RE: SUB19-002/SEP19-005 – Proposed Preliminary Plat  
2825 W. Mercer Way, APN 2174502425  
Request for Additional Information, Third Review

The City of Mercer Island Community Planning & Development Department has completed a third review of the application materials associated with SUB19-002/SEP19-005 for compliance with the Mercer Island City Code (MICC) for the above preliminary long subdivision application. All comments must be addressed prior to issuing the staff report and scheduling the public hearing.

10/12/22
 JOB NUMBER:
13-118
 SHEET NAME:
SP-01
 SHT **3** OF **9**

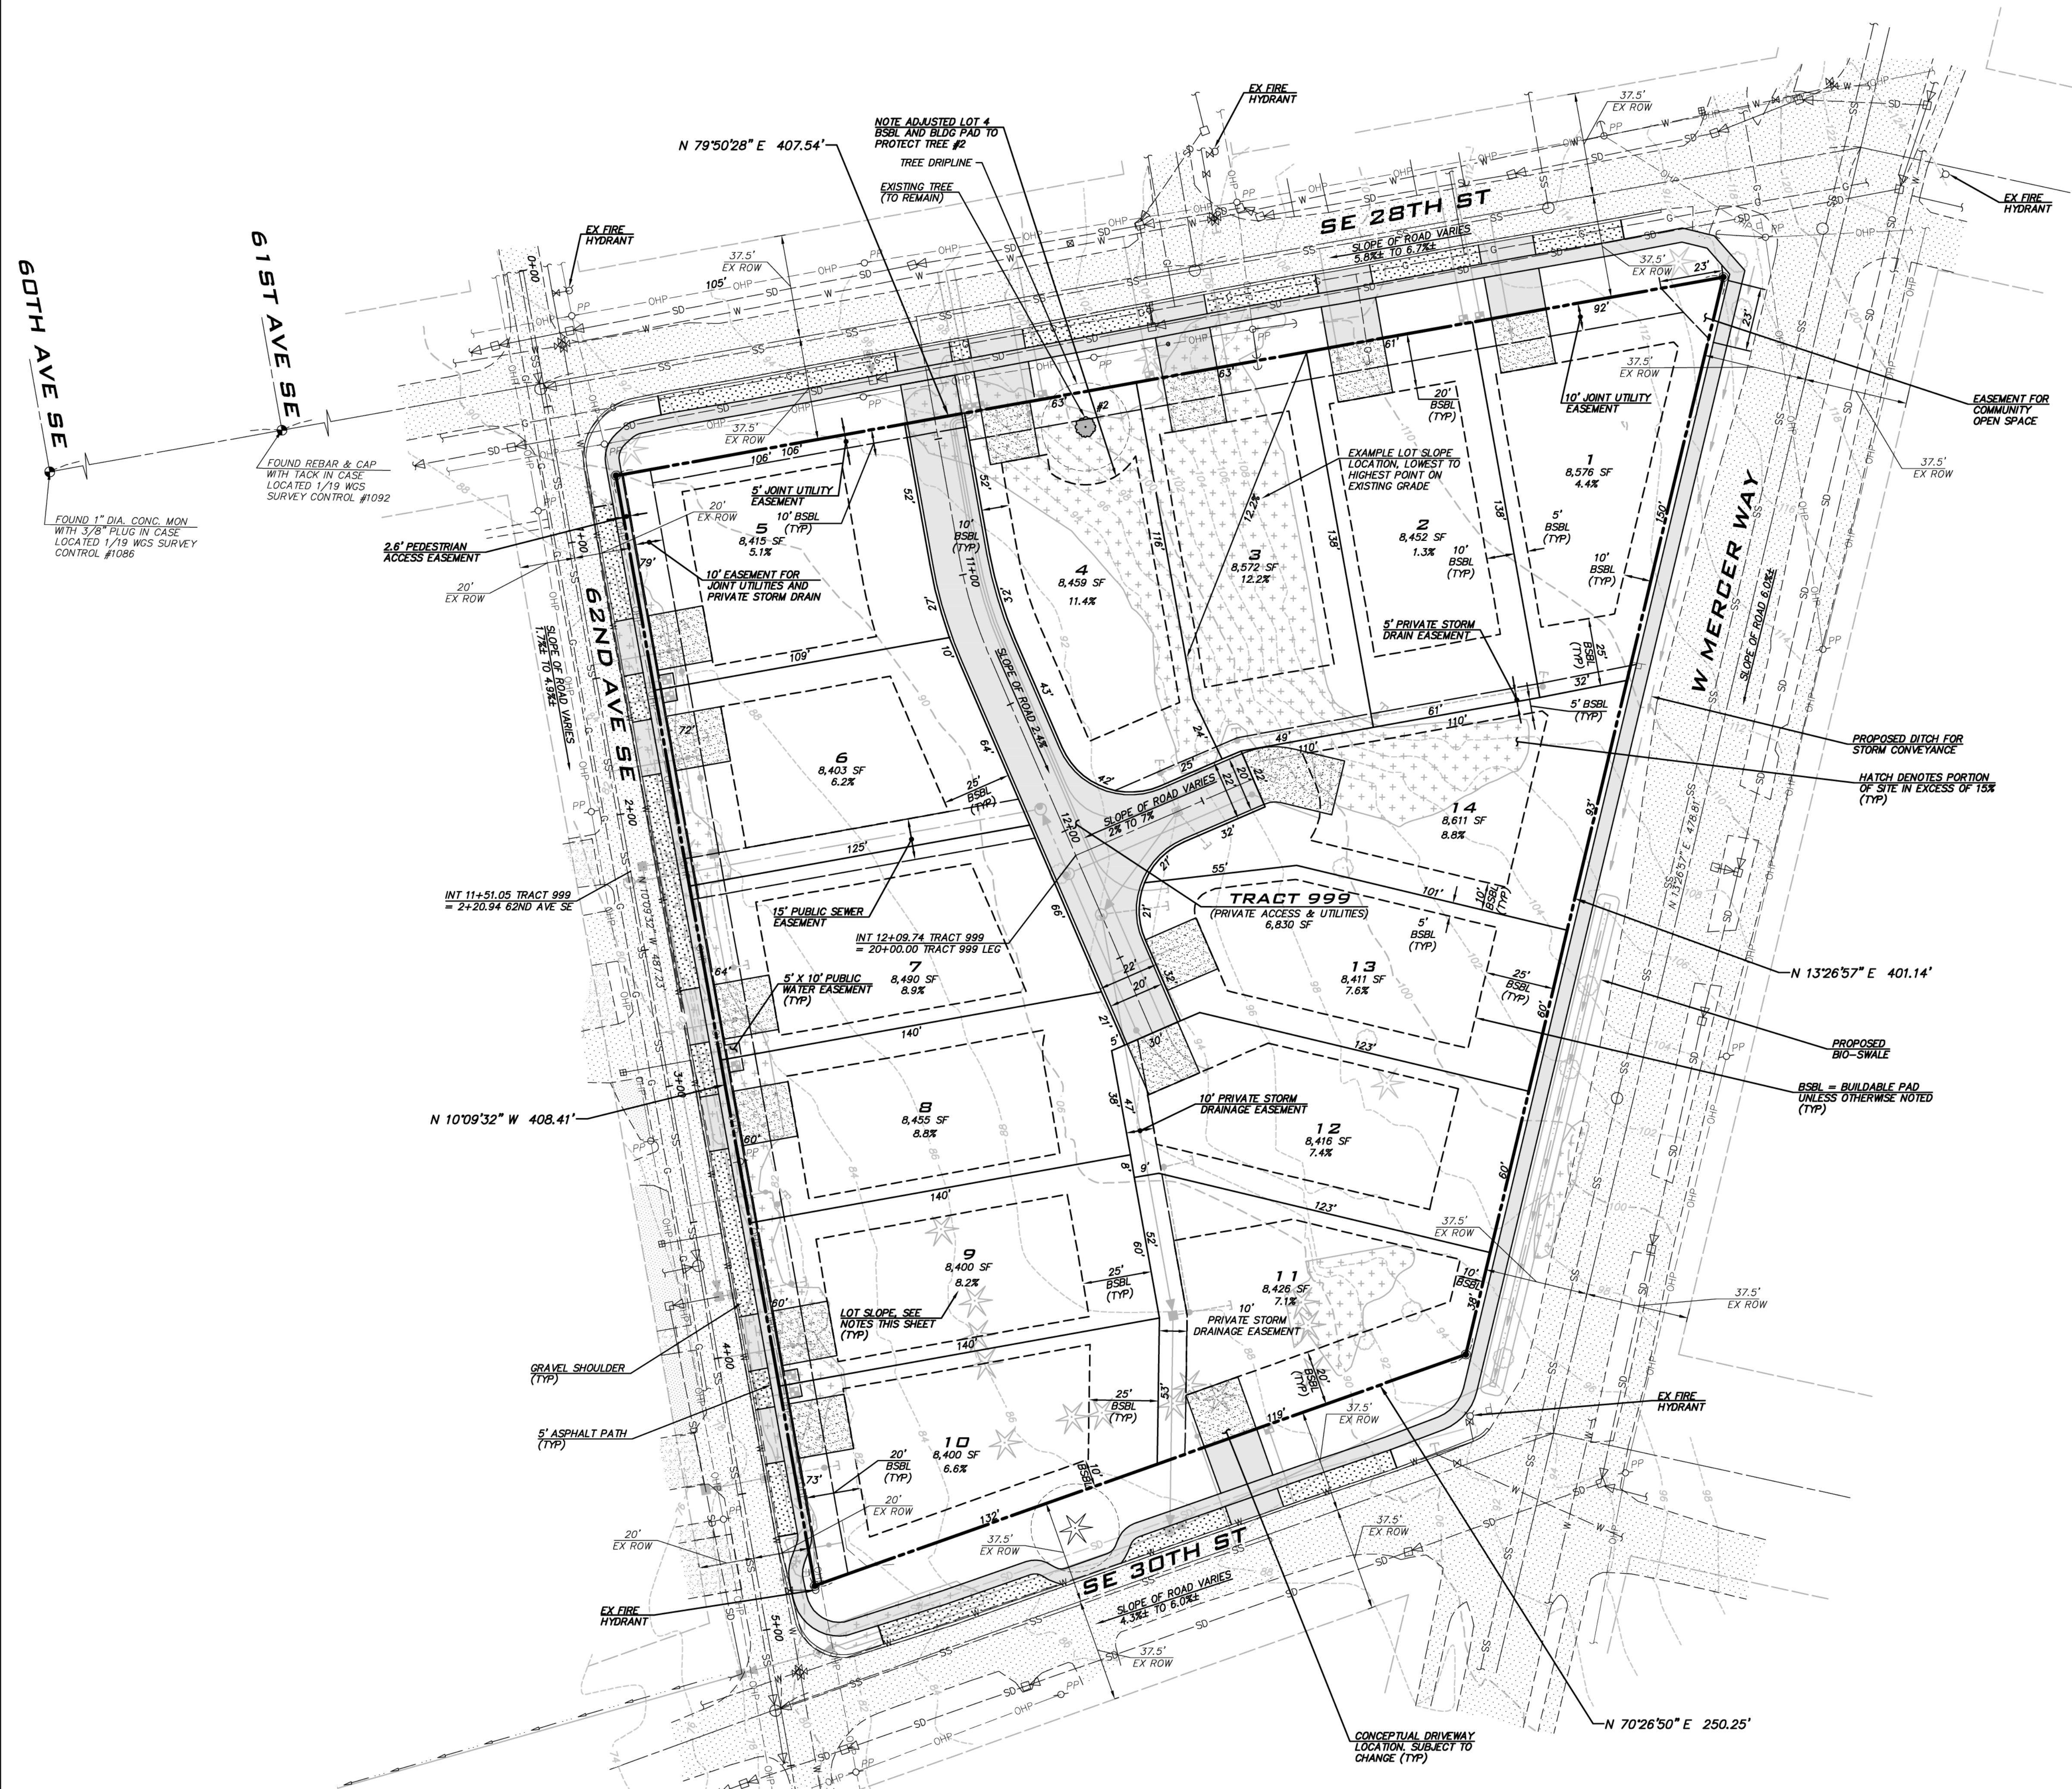
1. The sidewalk at the southwest of the intersection (W. Mercer Way and SE 28<sup>th</sup> Street) has too many turns and not ADA compliance. The sidewalk is too close to the PSE guy wire. A section of the property shall be dedicated to the City as ROW to accommodate the public sidewalk.

2. Please explain what the easement for community open space is for. Is this a private easement?
3. The side at the northwest of the intersection (W. Mercer Way and SE 30<sup>th</sup> Street) needs to connect to the roadway at all the intersections, in compliance with ADA.

4. The sidewalk along SE 28<sup>th</sup> Street needs to be located, so the existing catch basins will not be in the middle of the sidewalk or relocate the existing storm drainage system on SE 28<sup>th</sup> Street.

5. All sidewalks must be ADA compliance.
6. Storm Drainage and Utilities:
  - a. The bioretention system should not be in the City ROW.
  - b. Storm drainage design at the intersection of W. Mercer Way and SE 30<sup>th</sup> Street: Providing a new 10' of 12" DI pipe running north to south and adding a new Catch Basin at the end of the new 12" DI pipe, so the pipe's mouth is in line with the proposed ditch, rather than a 45 degree as shown.

PRELIMINARY UTILITY PLAN
2825 W MERCER WAY
PRELIMINARY PLAN
 PARCEL #2174502425
 CITY OF MERCER ISLAND WASHINGTON

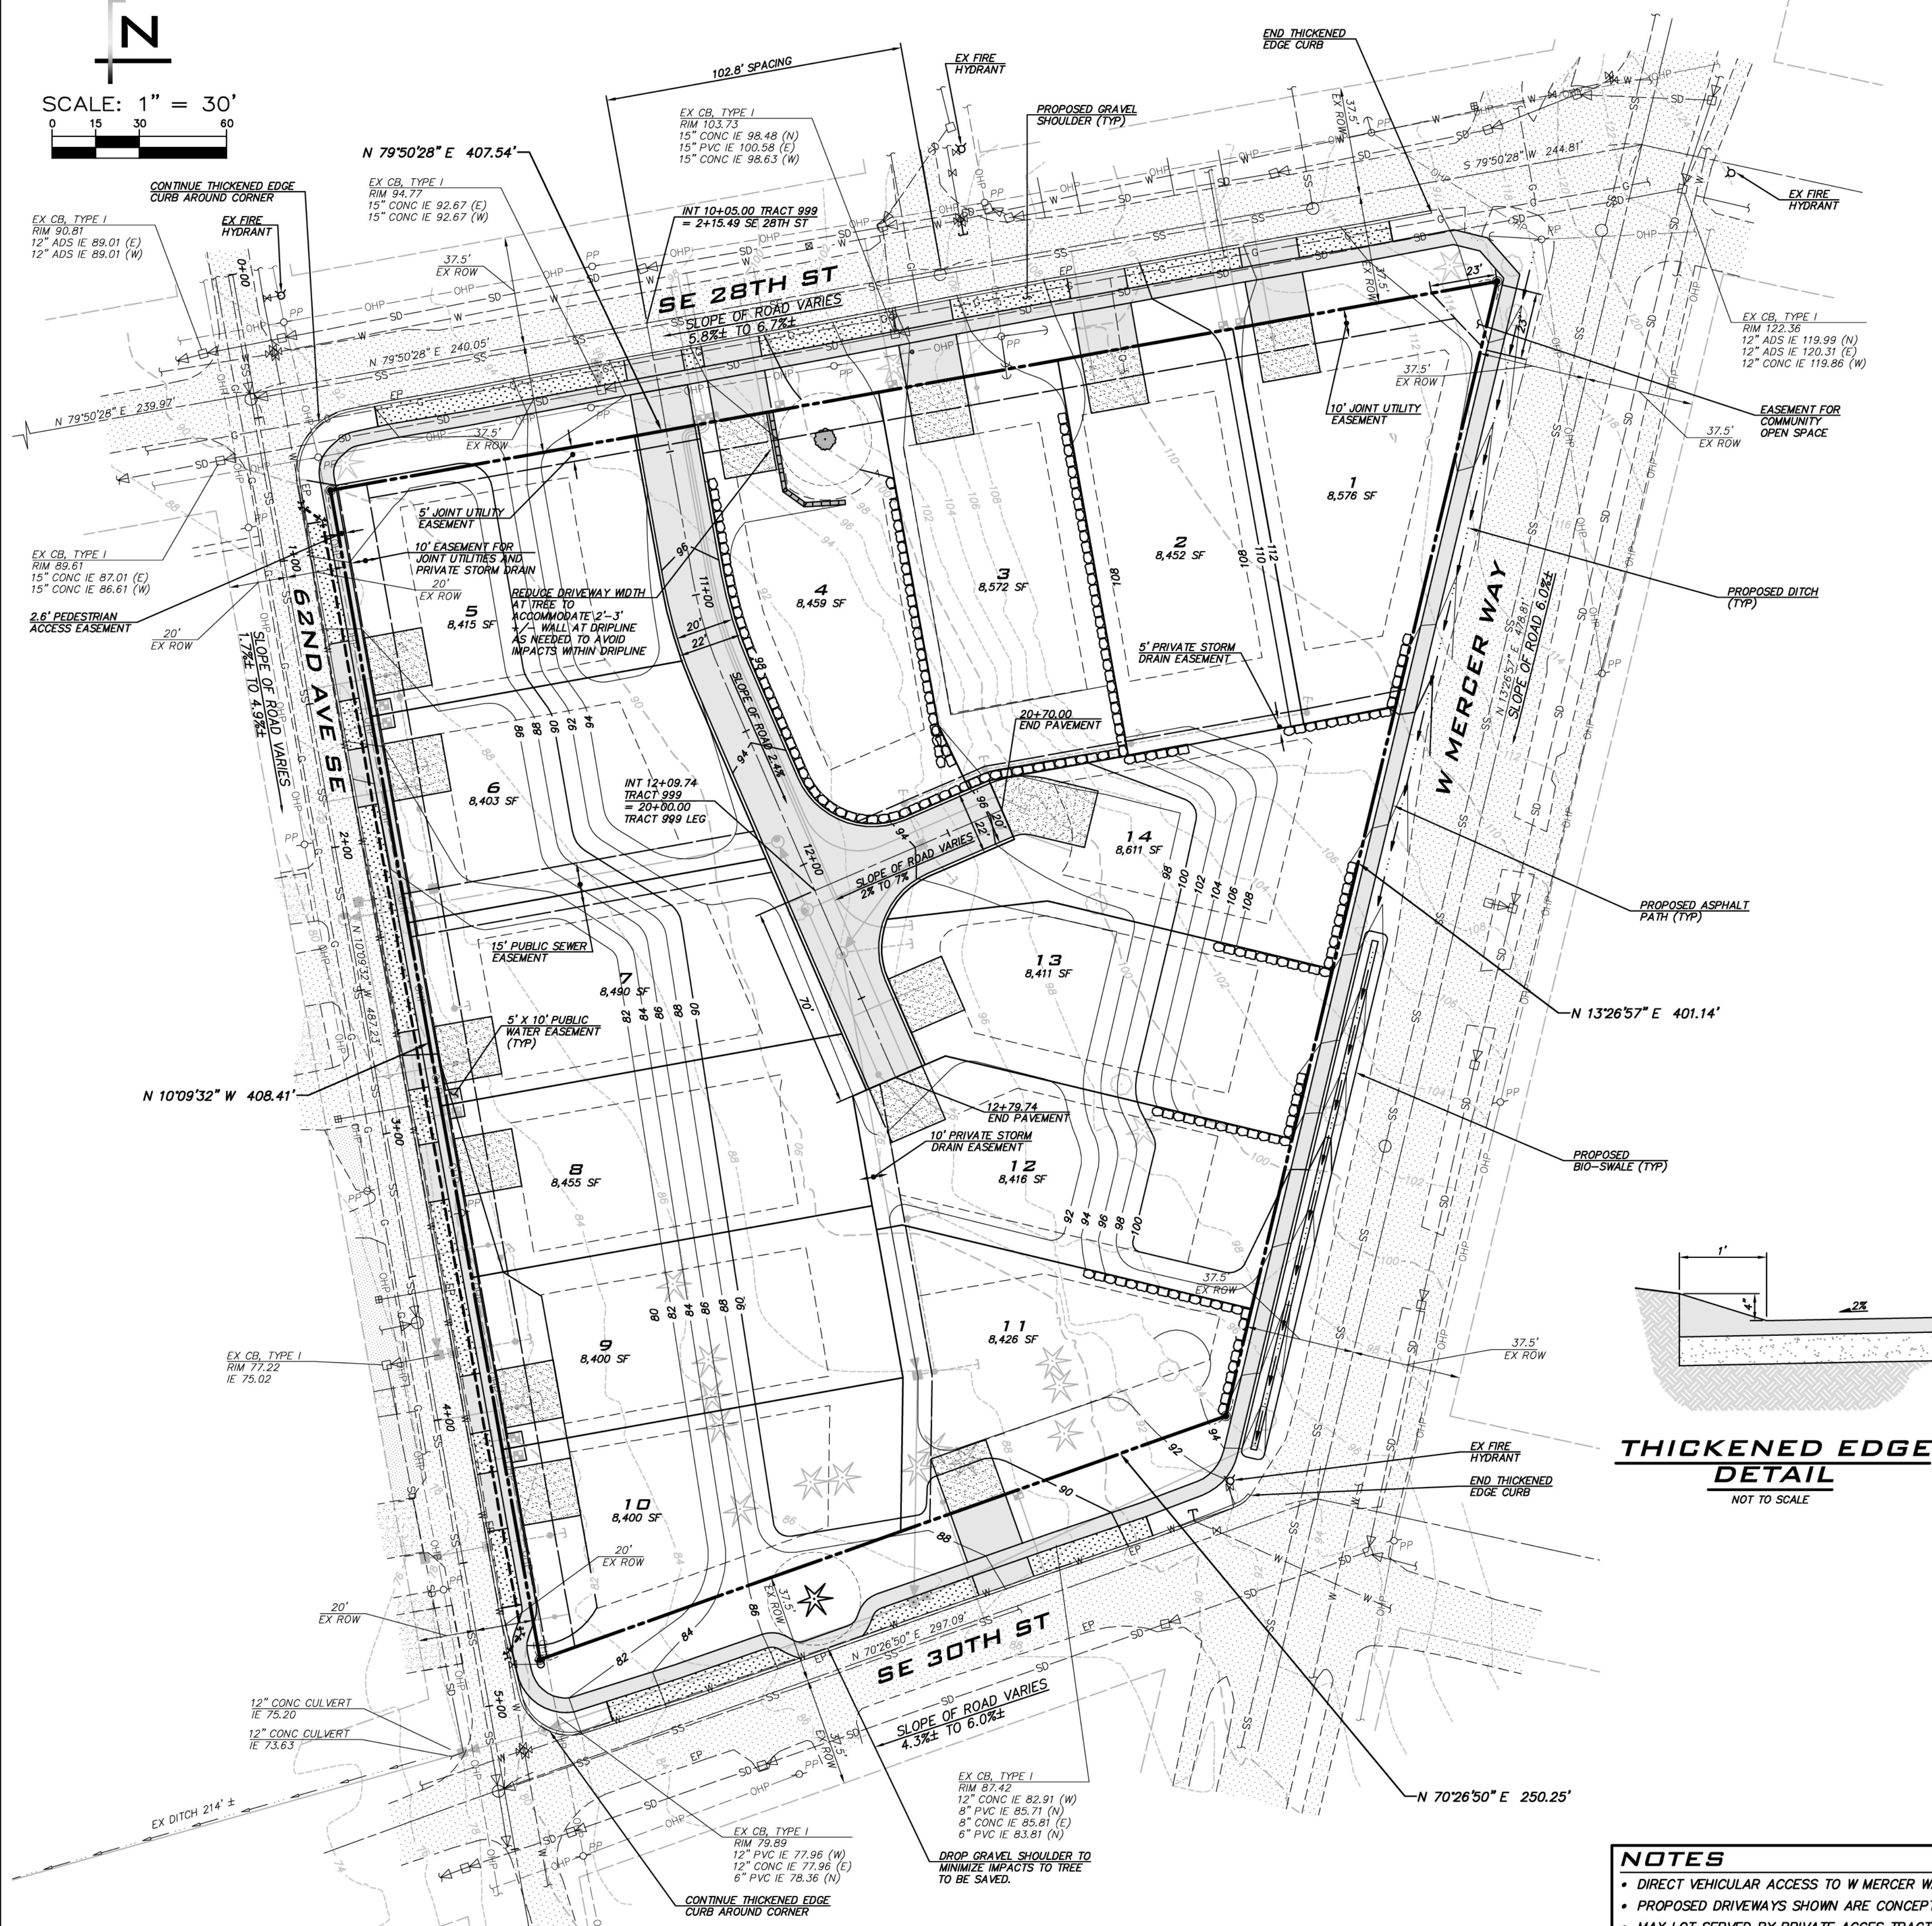
- c. The section of the existing ditch on 61<sup>st</sup> Ave. SE shall be piped and shown on the plan.
  - d. Additional Survey will need to be provided for the offsite drainage improvements.

- e. The sanitary sewer system for the plat is a private system, not a public system as shown.
  - f. The new water main will likely be a 12" DI and a water modeling will be required.
